August 29, 2016

Project No. 16055

## **Response to Comments – 7-Unit Building, 30 Merrill Street, Portland, Maine**

BRICK SIDEWALK WITH BITUMINOUS BASE
NOT TO SCALE

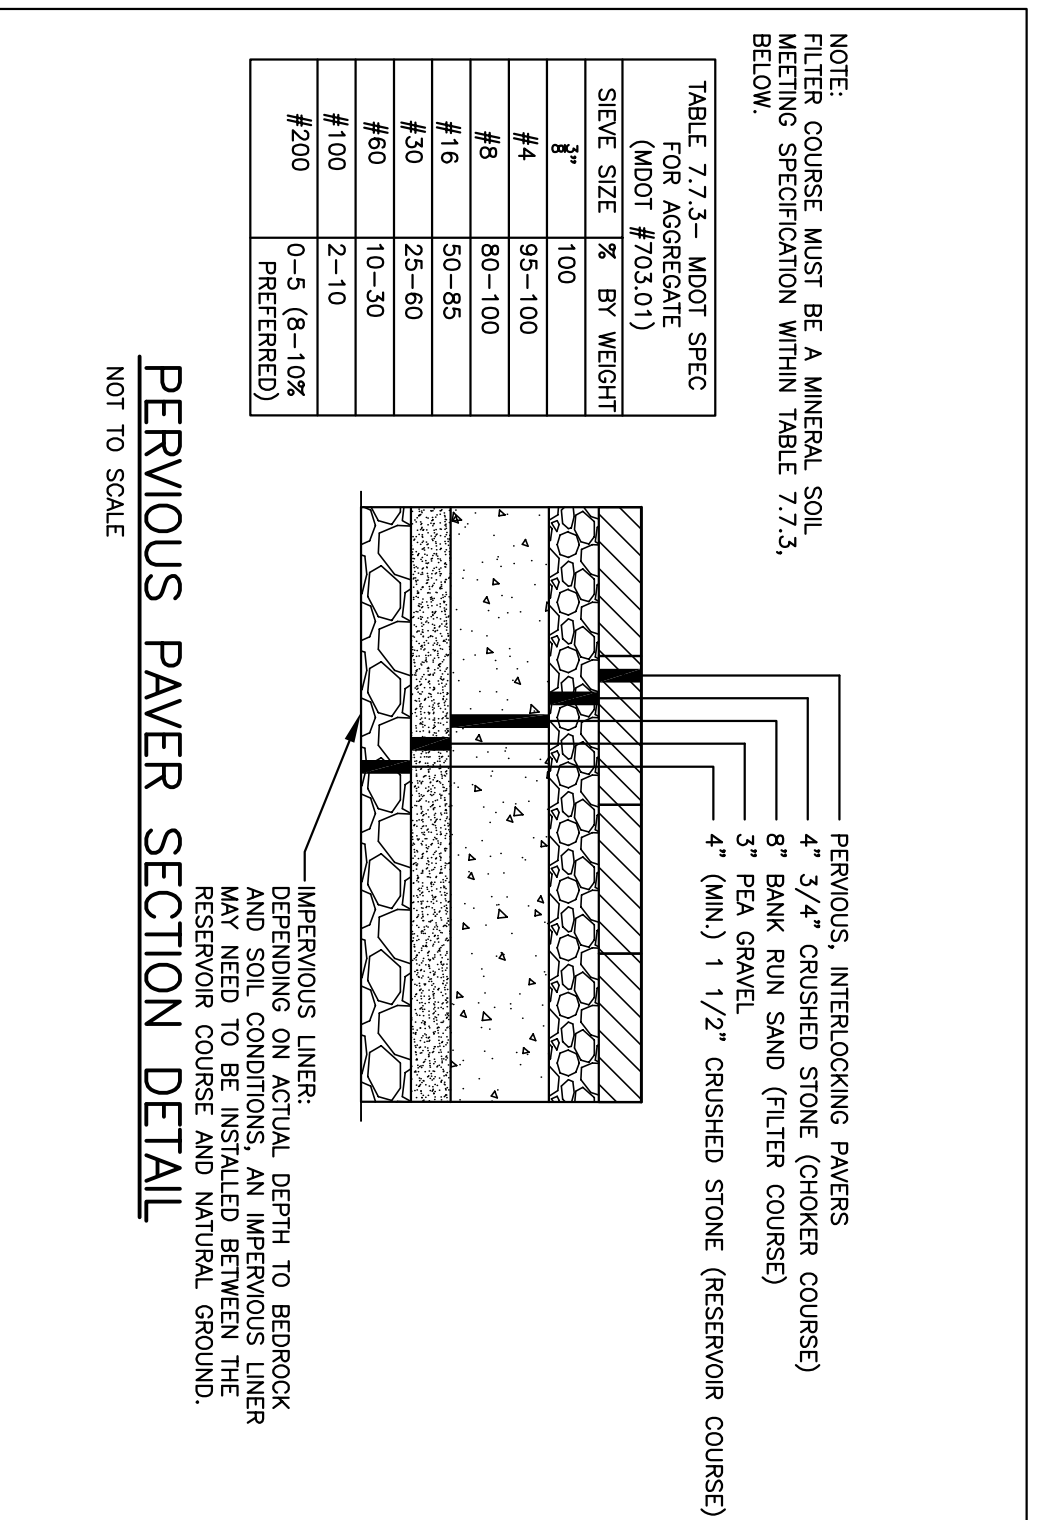
3) *The Applicant should provide a detail for pipe trenches, brick sidewalk repair, and pavement repair within the City of Portland Right-Of-Way per the City of Portland Technical Manual.*

We have added these details to the plans.

PERVIOUS PAVEMENT SECTION DETAIL
NOT TO SCALE

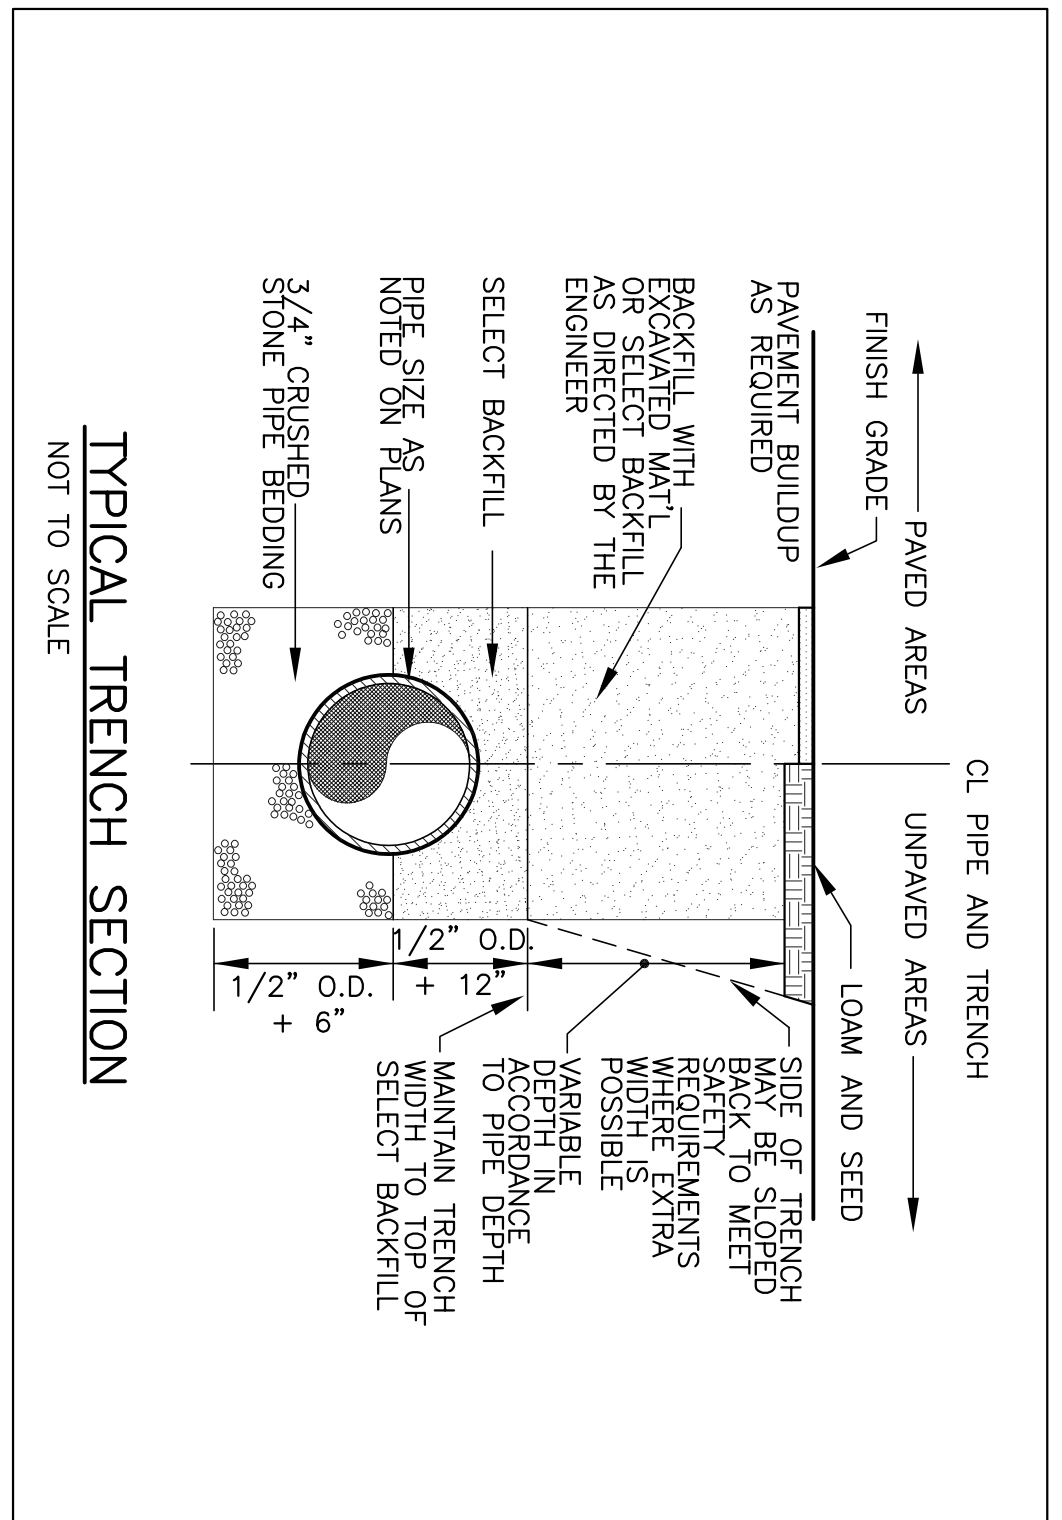
- The Pervious Paver Section Detail provided on Sheet C2 includes a Filter Layer; however, the Site Plan and stormwater management plan indicate that the limit of the proposed filter bed does not extend over the full area of proposed pervious pavers. A detail should be provided for paver installation in areas outside of the filter bed, to confirm that the entire paver area may be considered pervious. If the additional pavers are not installed in such a way that they are pervious, the impervious surface calculations should be updated, and the filter area should be designed per the Maine DEP Stormwater BMP manual's guidance for "Run-On Modular Pervious Pavement."*

- The Pervious Paver Section Detail should include specifications for the filter layer per Chapter 7.7 of Volume III of the MaineDEP Stormwater BMP Manual.*

The plans and calculations have been updated to show that the entire parking area and driveway are to be consistently constructed as pervious pavers.

We have added this information to the detail.

BICYCLE RACK SPECIFICATION - BIKE HITCH

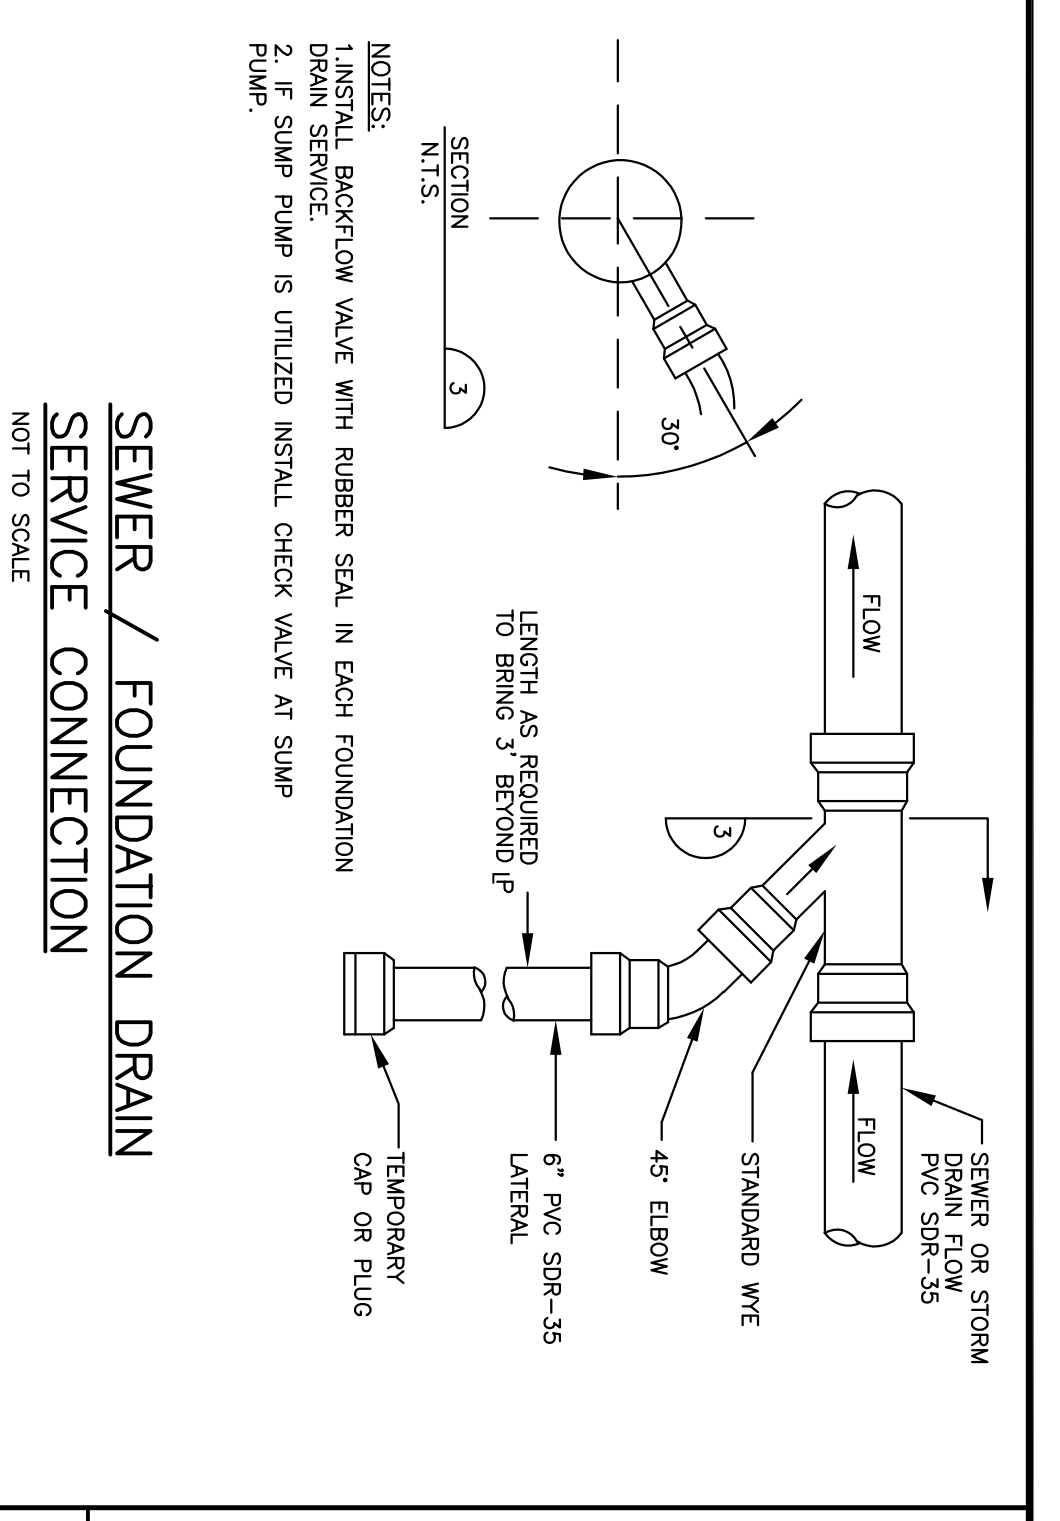
- *Bike Parking.*

To add to your response on this issue, we have added the location of the bike rack on the front sidewalk. We have provided an excerpt from the Technical Design Manual as well. This is located on the last detail sheet, Sheet C5.

PROJECT NAME: SIX-UNIT BUILDING 30 MERRILL STREET
 PORTLAND, MAINE
 SHEET NAME: SITE LAYOUT PLAN

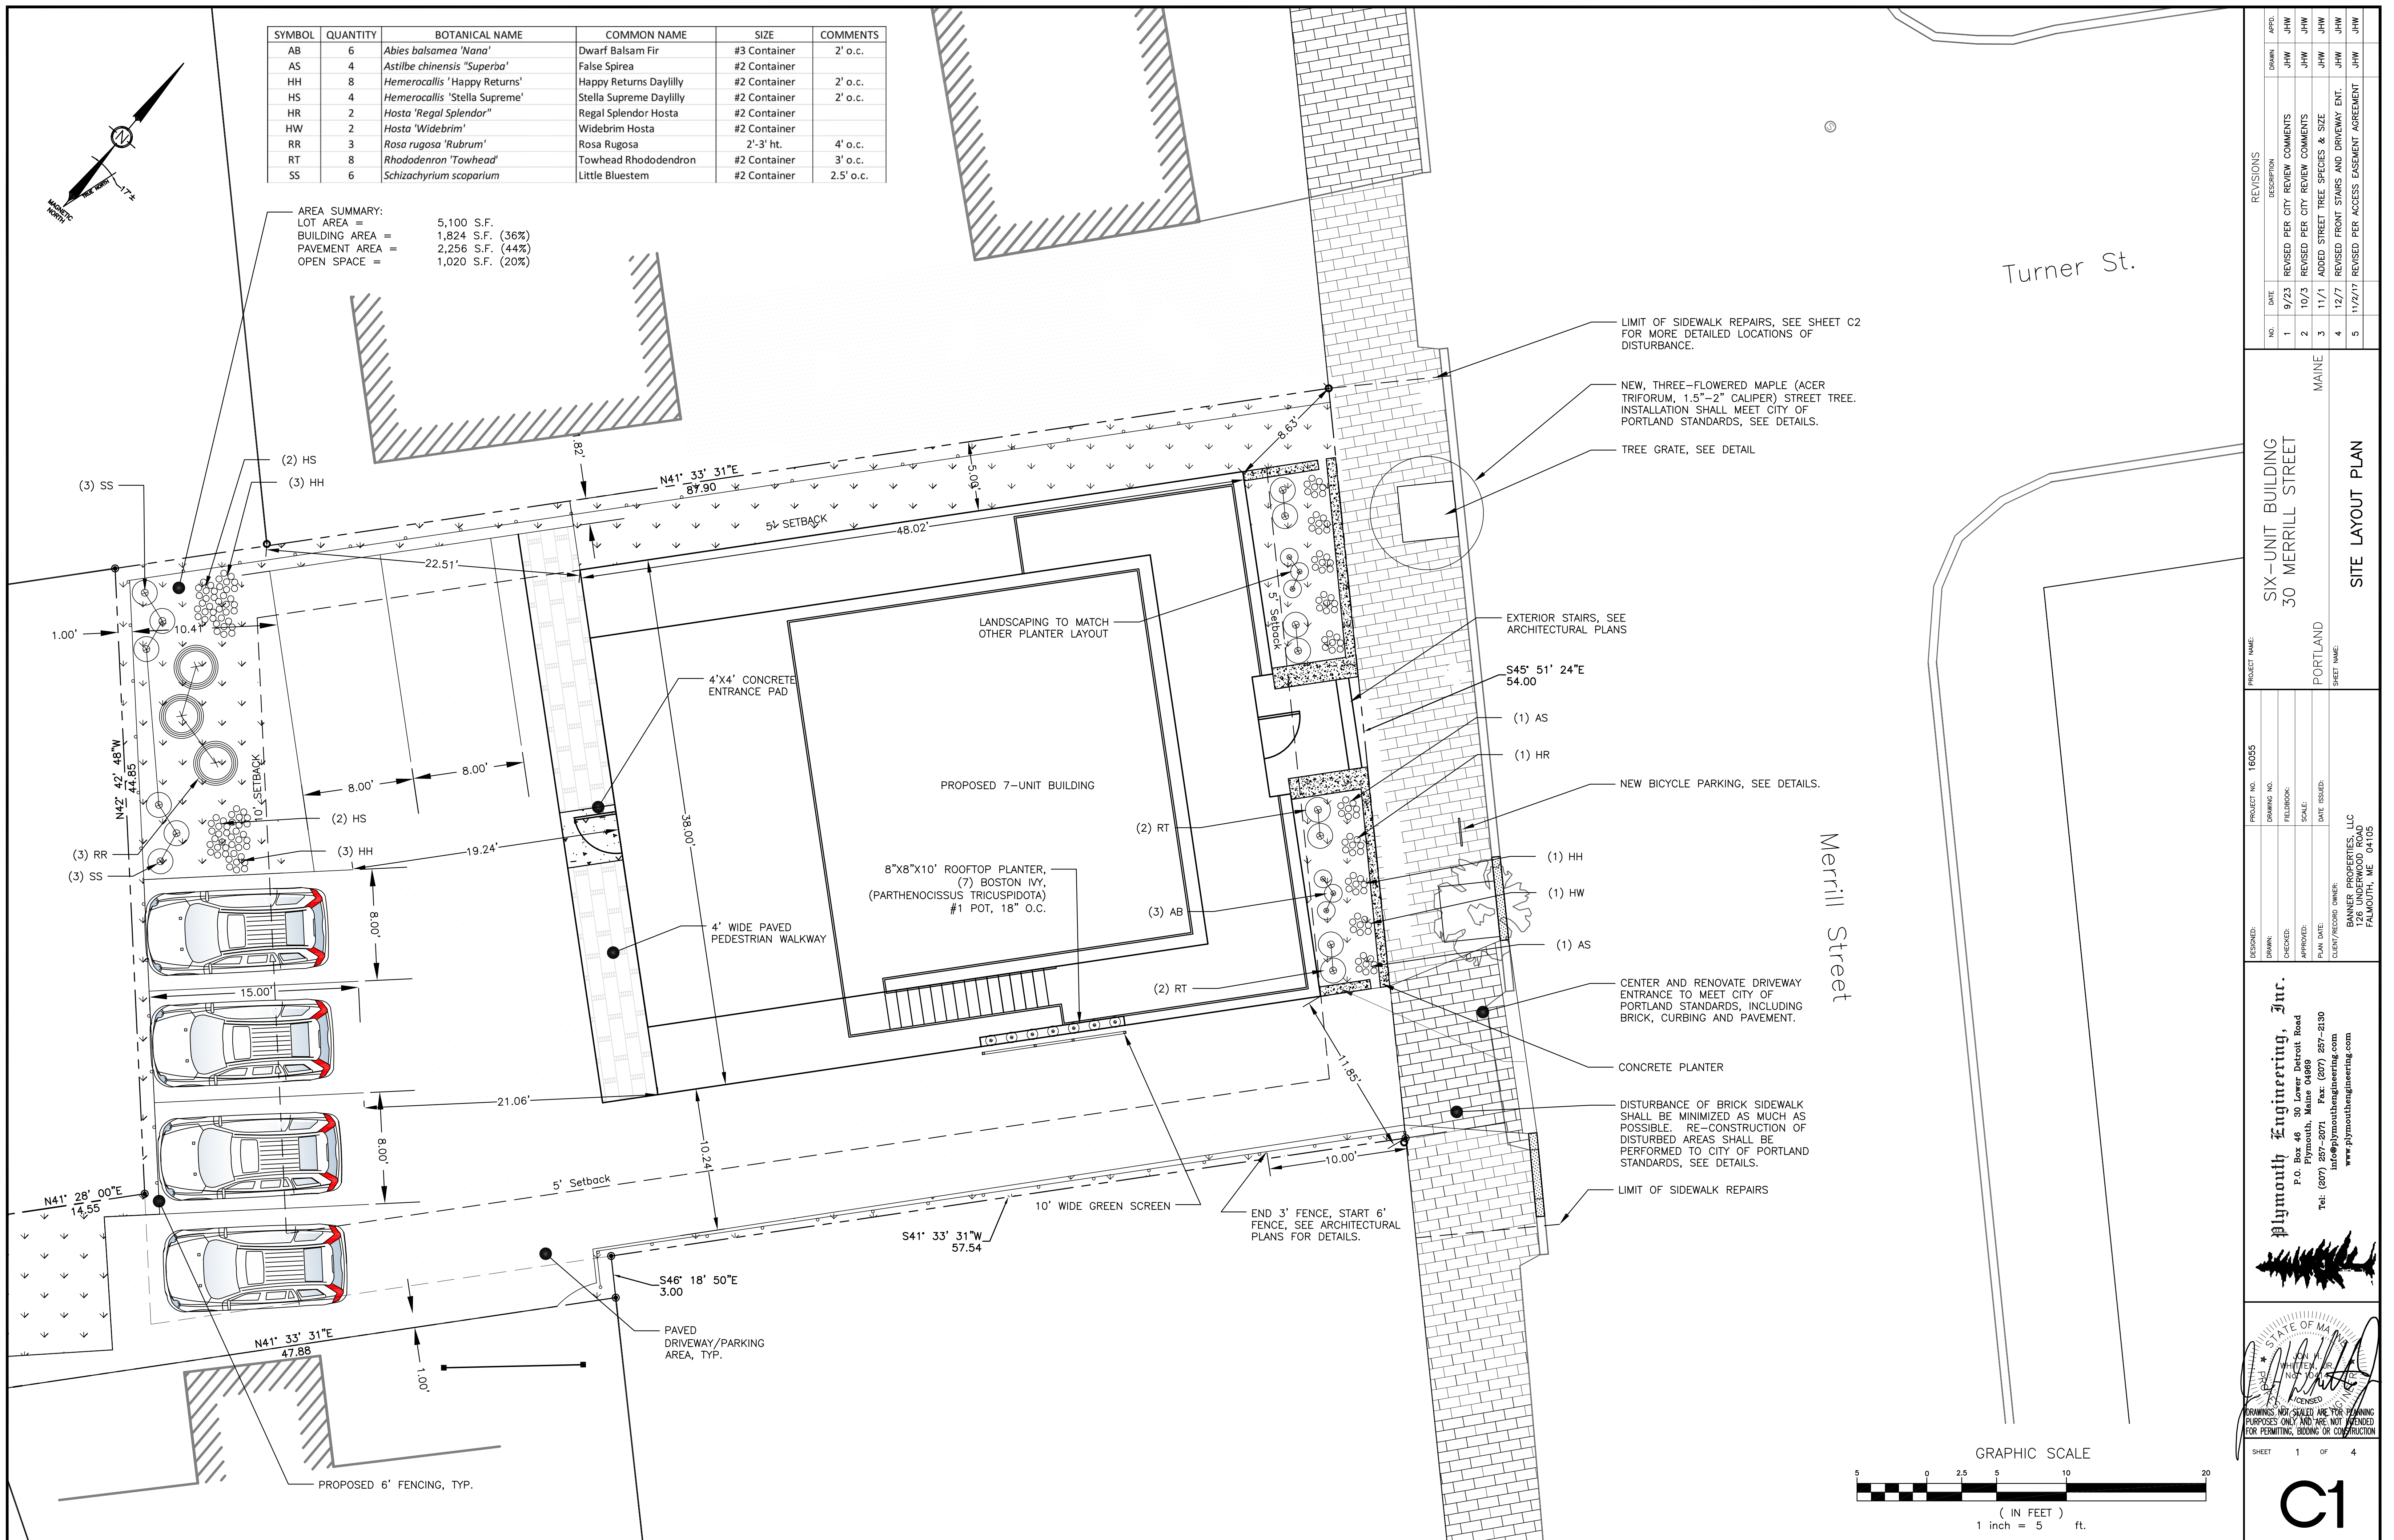
- *Need turning templates showing that parking area at rear will function adequately.*

- *The site plan depicts the driveway offset from the curb opening, while the existing driveway is centered. The applicant should note why an offset condition is proposed.*

- *Access and egress movements from parking spaces will be constrained. The applicant has provided vehicle turning templates that seem to illustrate parking space accessibility is feasible. Given the constrained conditions, I would suggest the applicant simulate the layout in a field test to be reviewed by me. I would note that the parking space adjacent to the handicap space will be difficult to maneuver into and out of.*

We have provided a plan showing 4 turning templates illustrating 4 typical car movements within the proposed parking area. The published turning radii for Honda and Toyota compact cars was found to be 17.7'. We used this turning radius for the turning templates used on the plan.

The existing driveway is 7.85' wide, is located on the southerly property line and is 1.5' offset from the southerly edge of the existing curb opening. The existing curb opening is 10 feet wide, at the narrowest point. The proposed driveway is to be 10 feet wide and located 1-foot away from the southerly property line. This results in the existing curb tip-down on Merrill Street being 1.25 feet offset from the northerly edge of the proposed driveway. It leaves 9.20 feet of clear access between the proposed fence and the existing tip-down curb. This width appears to be adequate for access of residential scale vehicles and minimizes impacts to the existing sidewalk and curbing on Merrill Street.

If the applicant were to remove the parking space closest to the building, would that eliminate the request for a field test? I believe the required number of parking spaces is 4 for this property. If so, we will discuss this with the applicant.
